Application for a Non-Material Amendment Following a Grant of Planning Permission

Add window overhangs

GROUND FLOOR PLAN

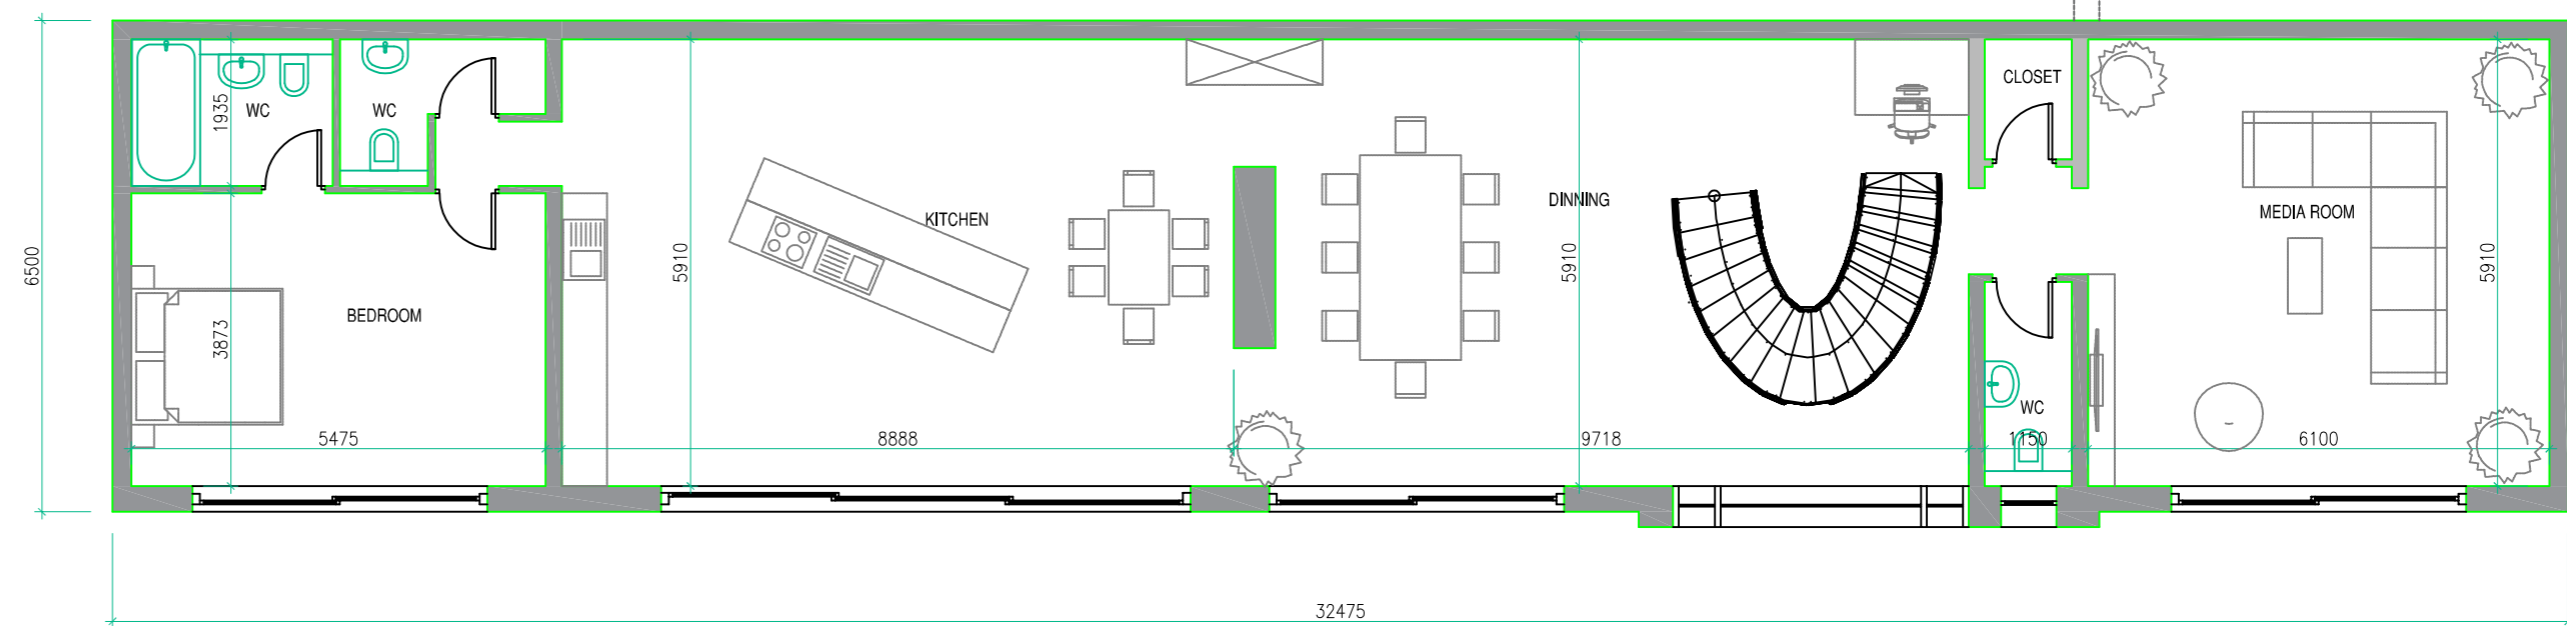
The conservation officer on the original application, Maeve Faulkner, made a comment in an email to us at the time that "simple modern designs such as this live or die with their details. In this case, as already mentioned, I would like to see deeper window reveals to give some contrast in the facades. While the works have been ongoing we have asked a new architect to look at the elevations with this in mind and they have proposed overhangs in line with Maeve's comments which we believe achieve the deeper window reveals and give contrast in the facades that she envisaged.
